State of Washington
DEPARTMENT OF FISH AND WILDLIFE

January 19, 2017

RE: WDFW comments on SP-16-00005 Double K. Ranch Short Plat along Badger Creek

Long narrow strip of Lot 1 mostly within the Wippel Wasteway setback area

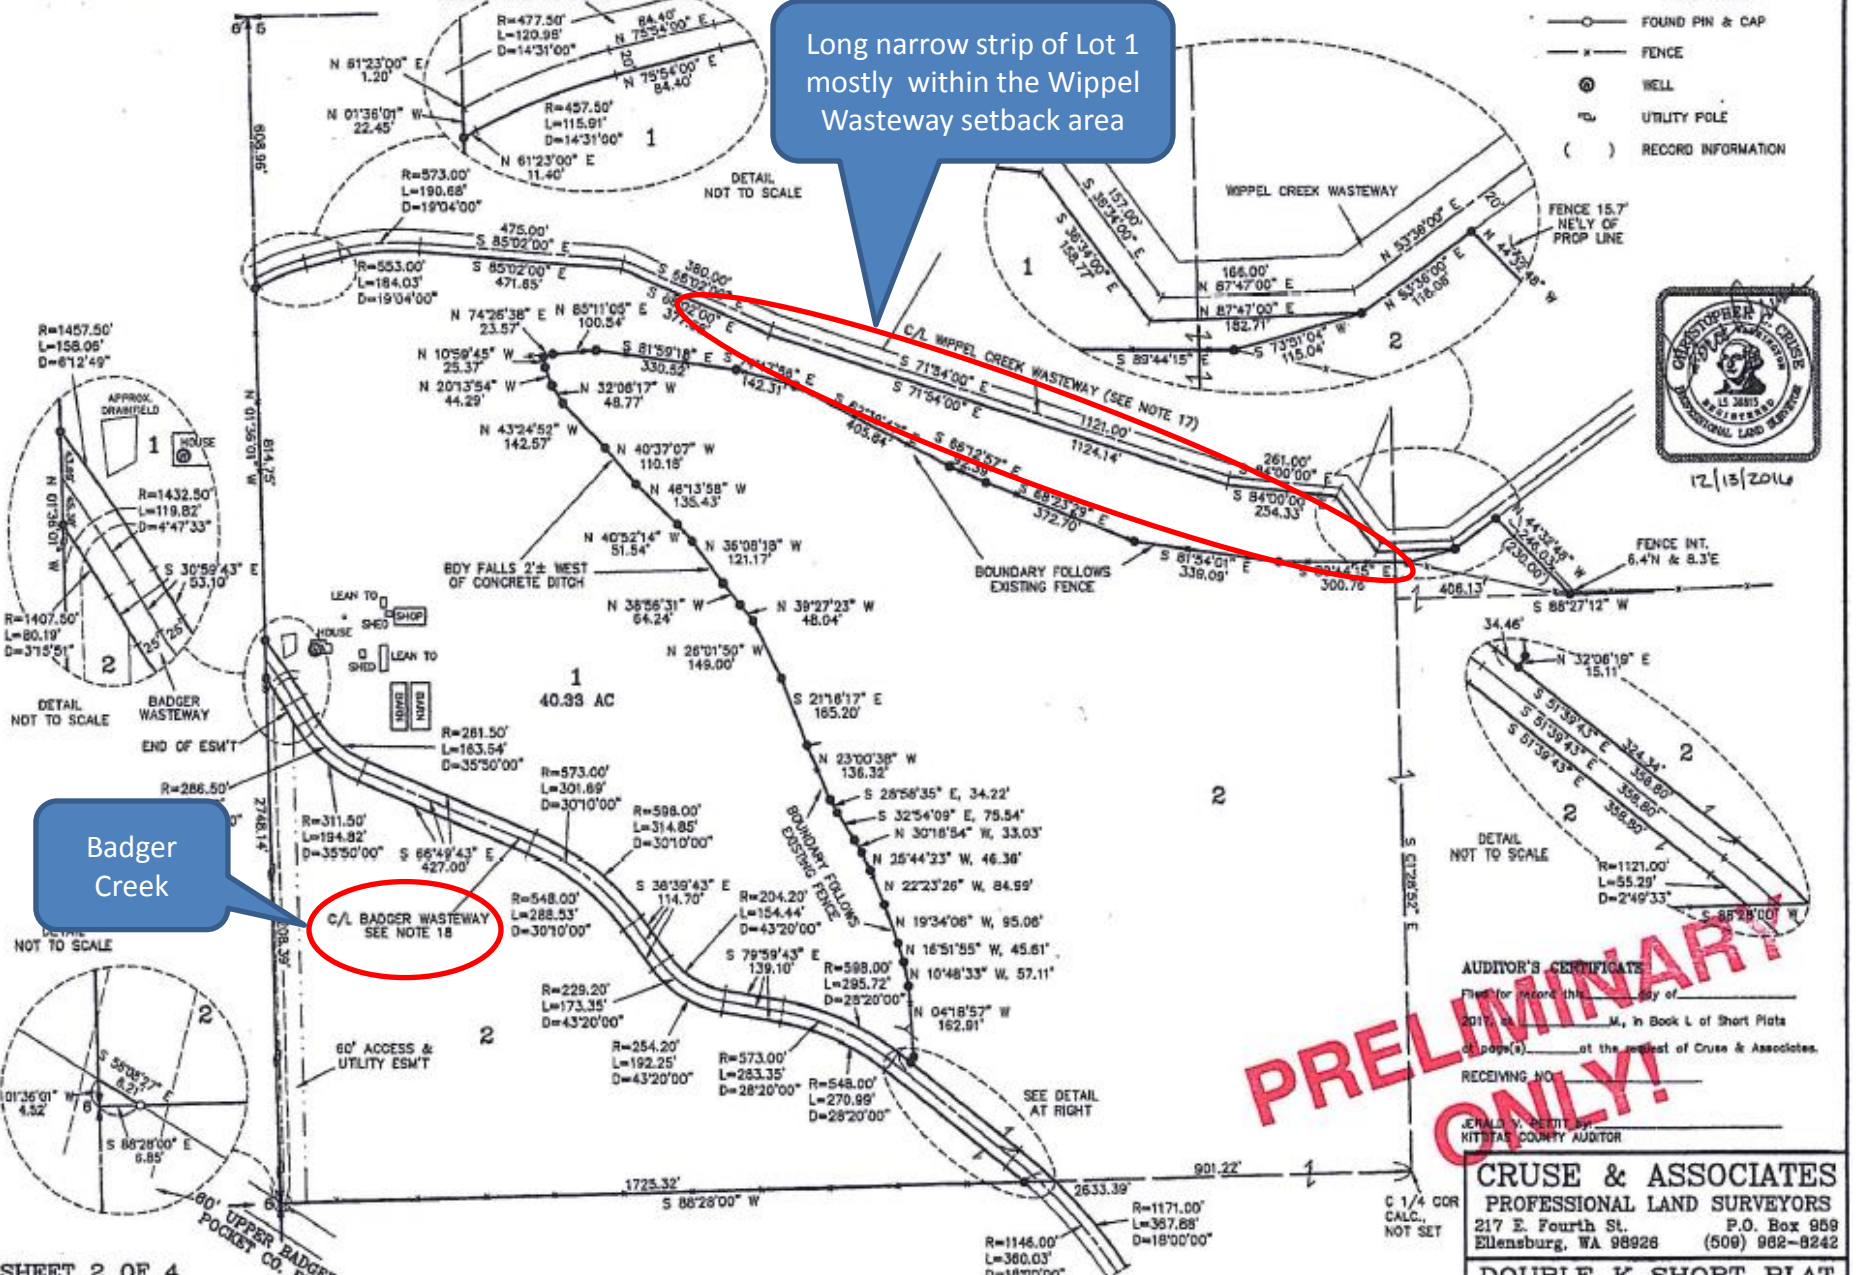
- Consider alternatives to using Badger Creek as the property boundary along the southwestern border
- Consider changing the configuration of the lot line on the northern part of the property such that Lot 1 does not have a long narrow strip of riparian buffer along Wippel Wasteway. Much of this “strip” should remain protected to function as a critical area buffer with wetlands and fish and wildlife habitat
- Early consultation with WDFW prior to development of Lot 2 and/or further development of Lot 1

C/L BADGER WASTEWAY
SEE NOTE 18

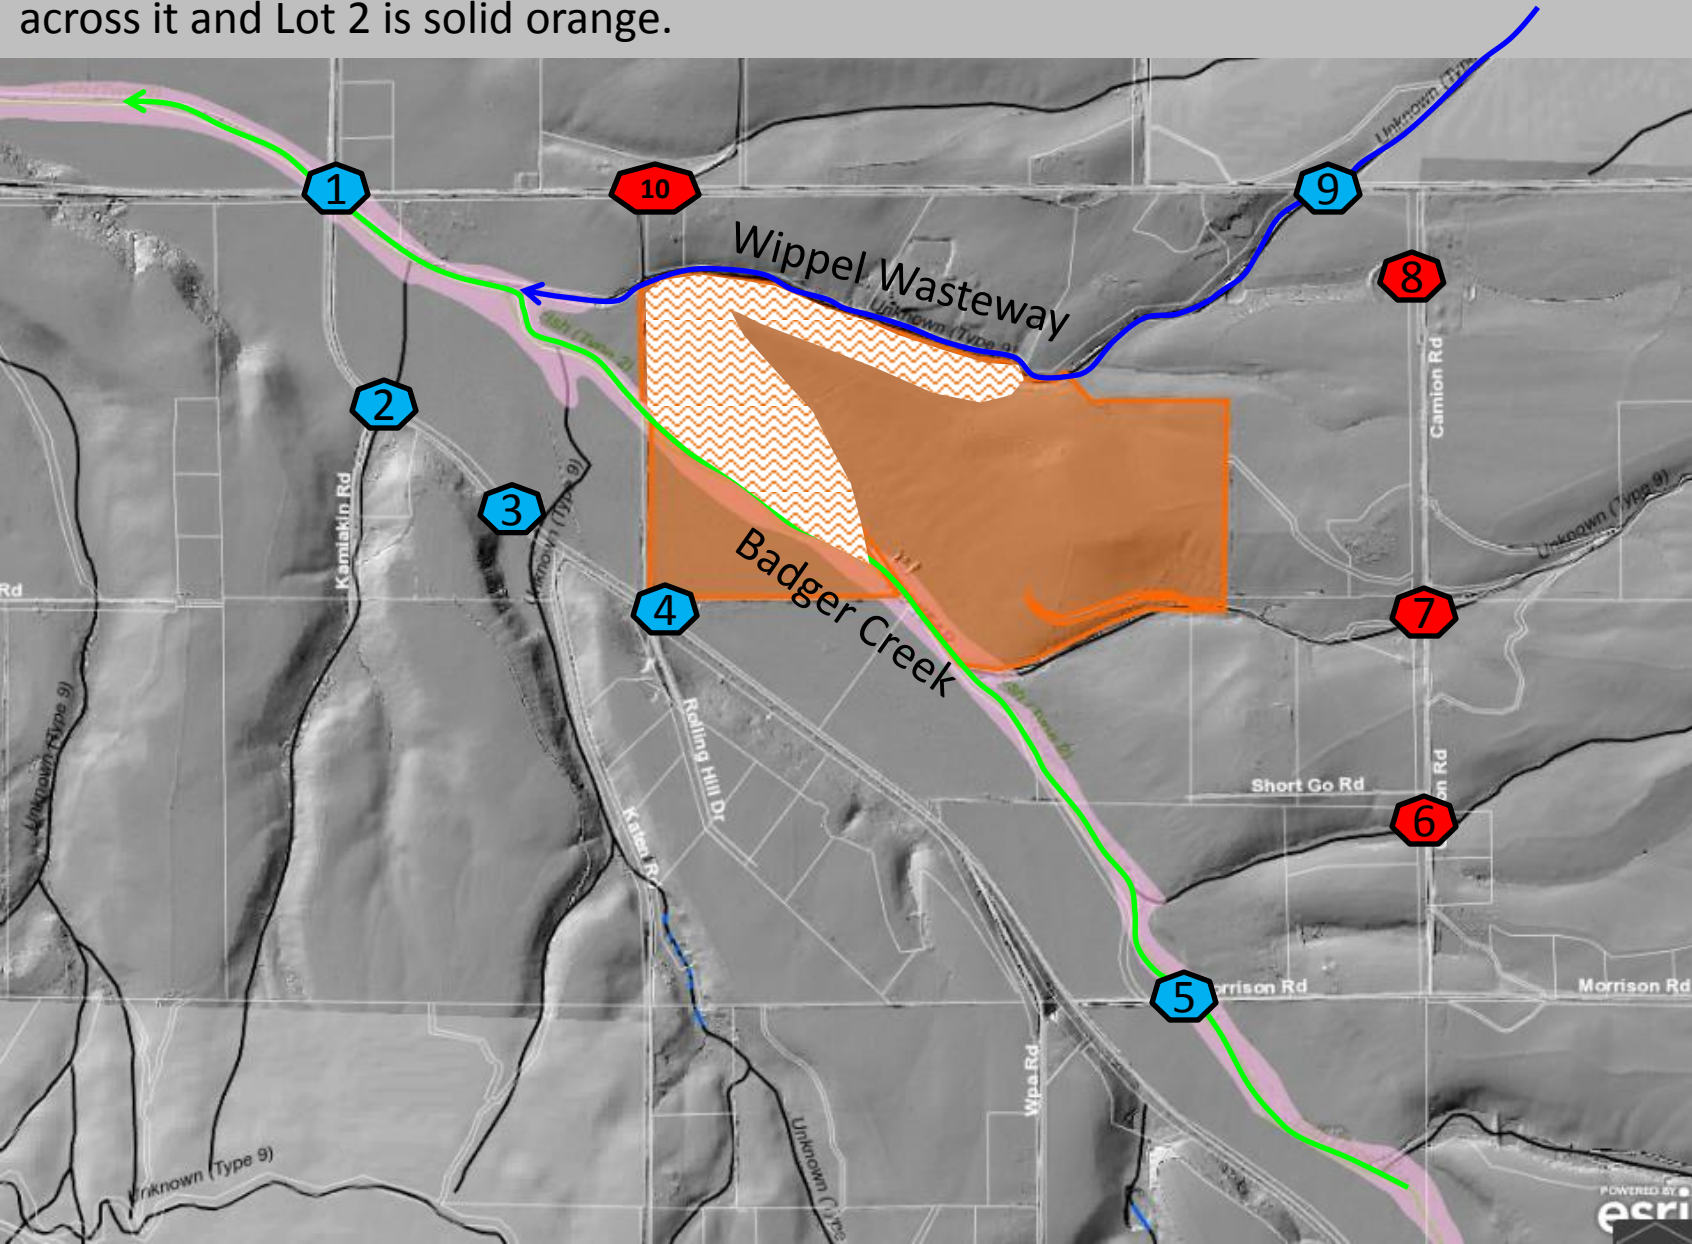
- The name Badger Wasteway be changed to Badger Creek on the surveys to reflect the natural water course
- A critical areas buffer and setback be shown on the survey for Wippel Wasteway and Badger Creek
